OXFORDSHIRE COUNTY COUNCIL'S RESPONSE TO CONSULTATION ON THE FOLLOWING DEVELOPMENT PROPOSAL

Application no: 23/01941/F

Proposal: Variation of Condition 3 (plans) of 19/02708/OUT - To vary the approved parameter plans

Location: Bicester Heritage, Buckingham Road, Bicester

Title
Proposed Land Use

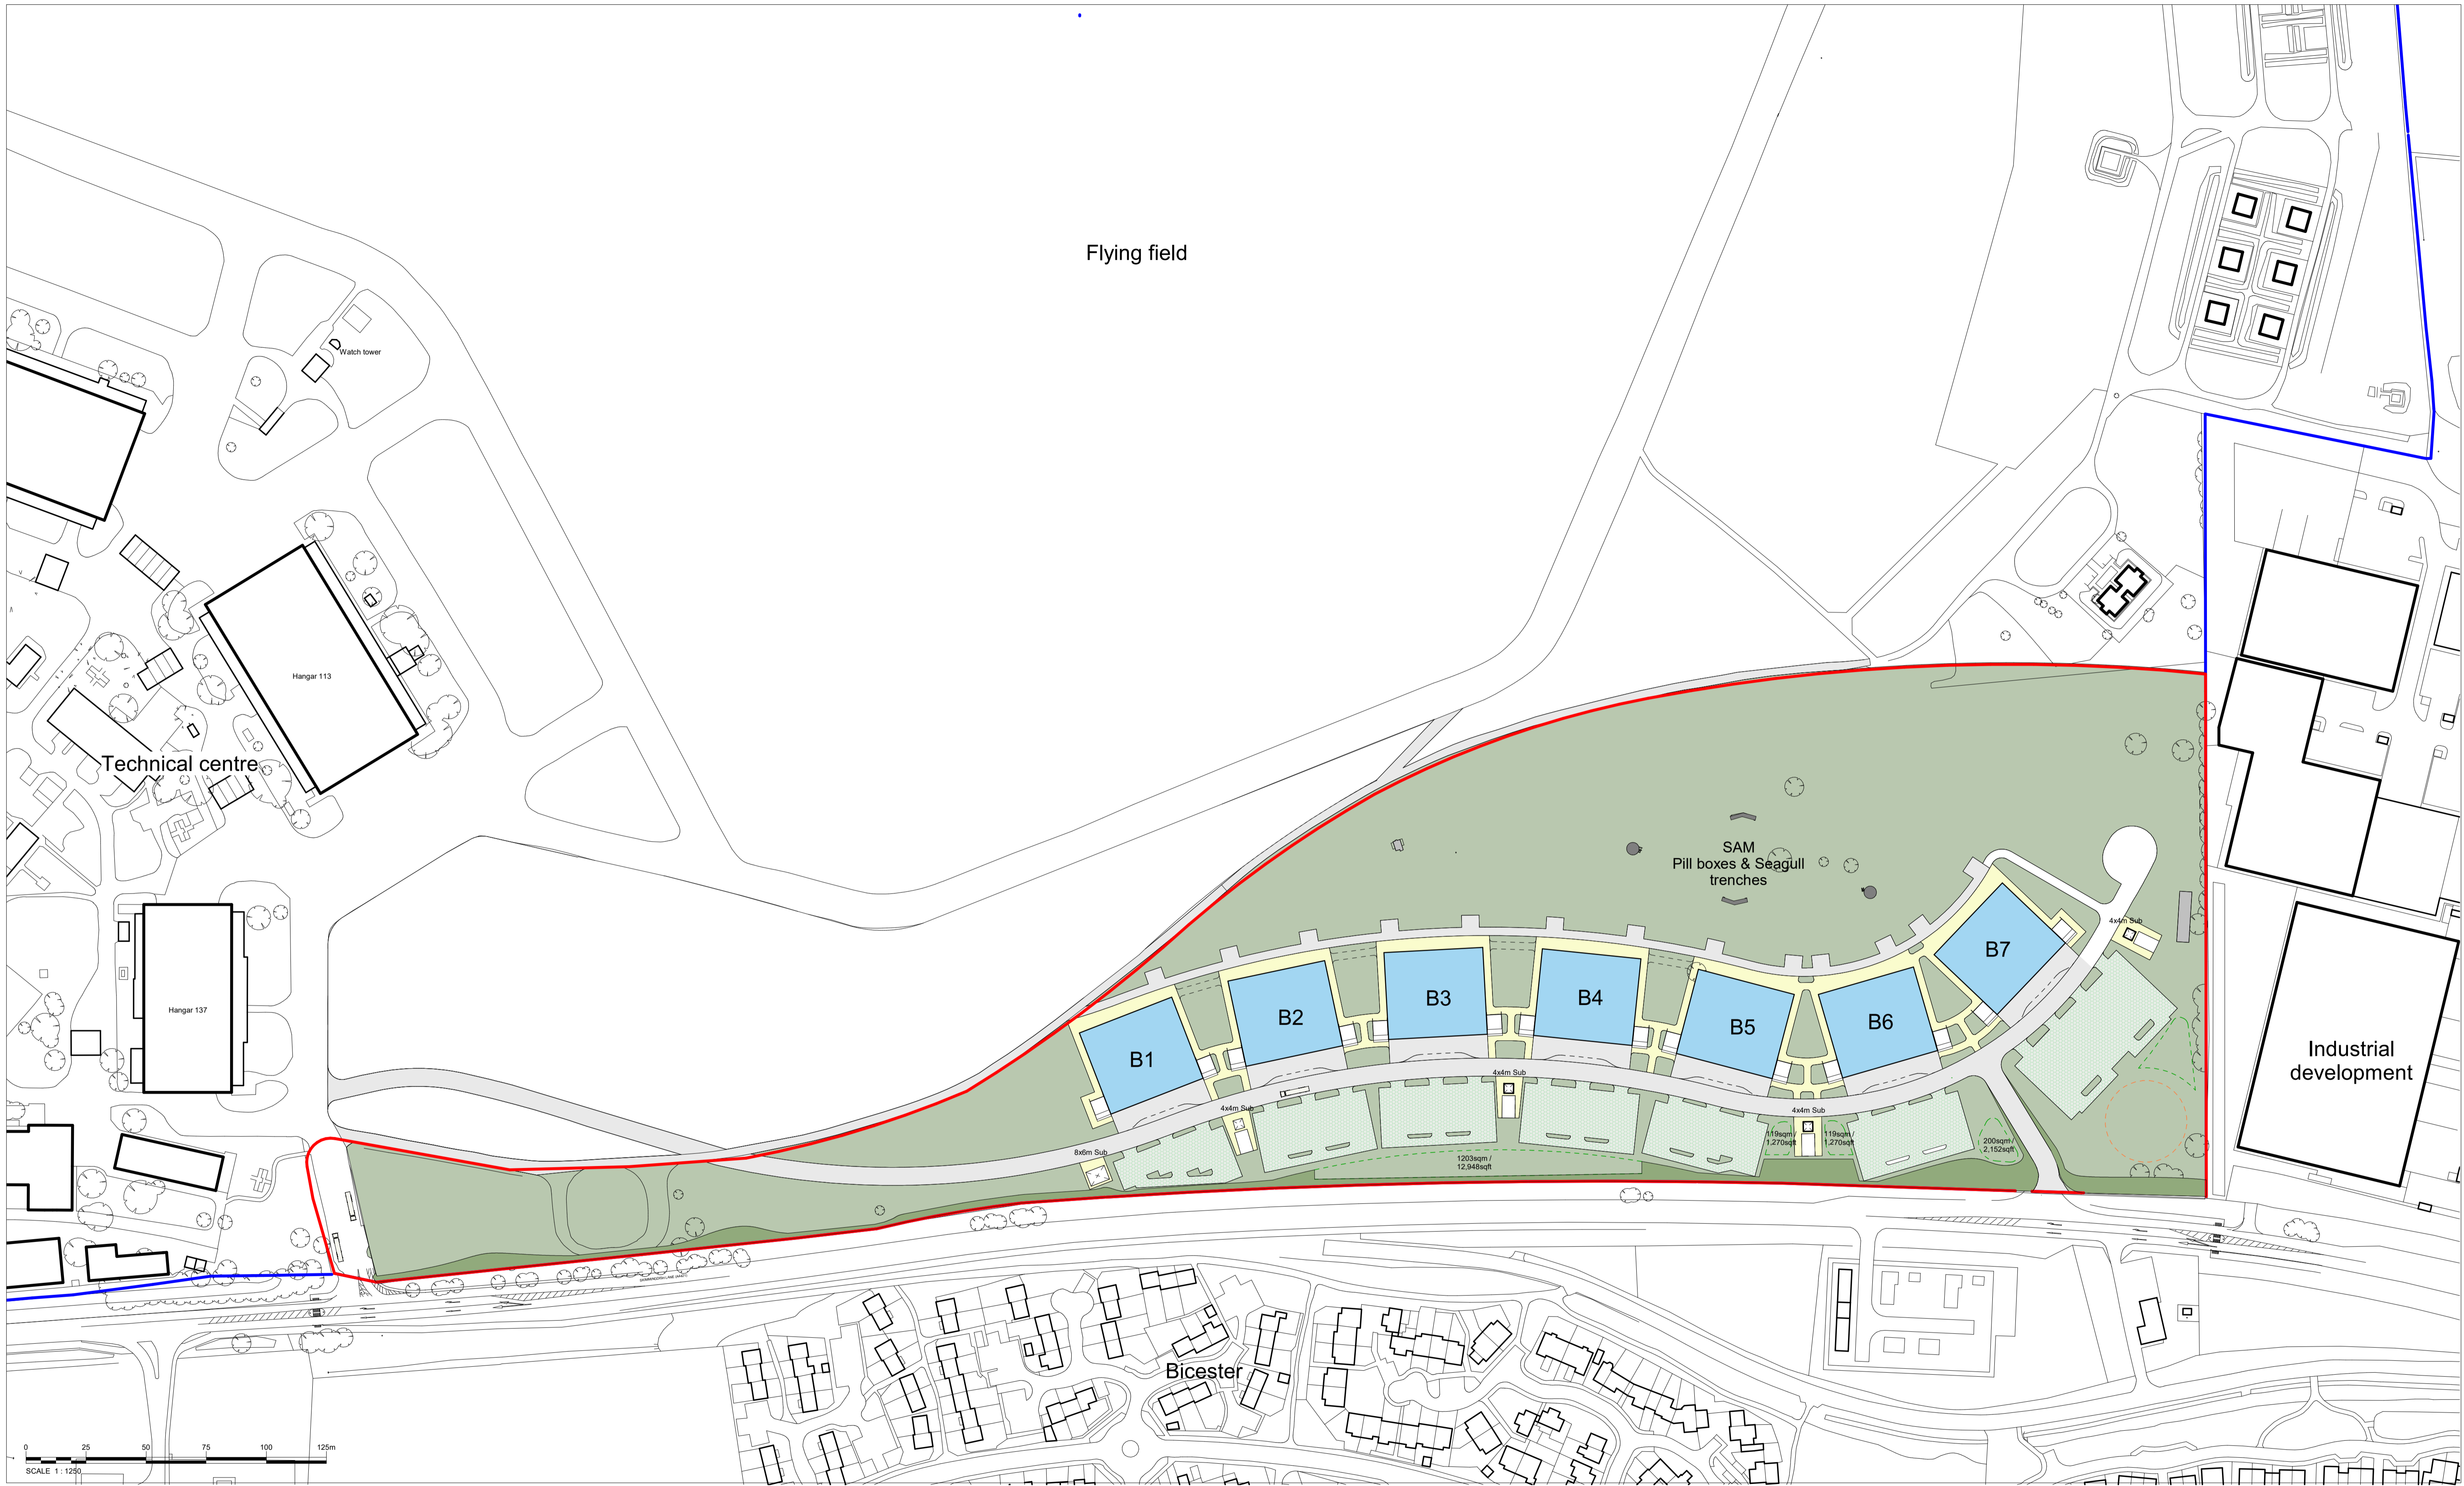
- The potential level of parking set out in the revised parameters plan (401 spaces) exceeds that which was approved under ref 19/02708/OUT (348 spaces) as well as the county council's adopted standards. This increase in parking has not been justified nor its impact assessed.
- The level of cycle parking proposed on the revised plan (88 spaces) is significantly less than previously approved under planning ref 19/02708/OUT (108 stands / 216 spaces).
- The increase in car parking provision and reduction in cycle parking does not encourage sustainable travel to the site and is contrary to policy.

I do not object to the revised parameters plan in principle, however I note that the planning statement sets out that the revised masterplan can accommodate up to 401 car parking spaces. This is an increase on the 348 spaces set out under the approved application 19/02708/OUT and is significantly above the level set out in the county council's recently adopted car parking standards. No justification or analysis has been provided to support the increase in car parking provision on the site. A greater level of car parking would increase car dependency and does not encourage the use of sustainable transport to the site.

The level of cycle parking proposed on the revised plan is also significantly less than approved under ref 19/02708/OUT and significantly less than the level set out in the recently adopted Parking Standards document. This would also lead to greater car dependency. The previous permission set out the provision for 216 spaces.

Noting that permission has been granted for a development with 348 car parking and 216 cycle parking spaces, which was in accordance with parking standards at the time, I would not object to a revised plan which aligned with that level.
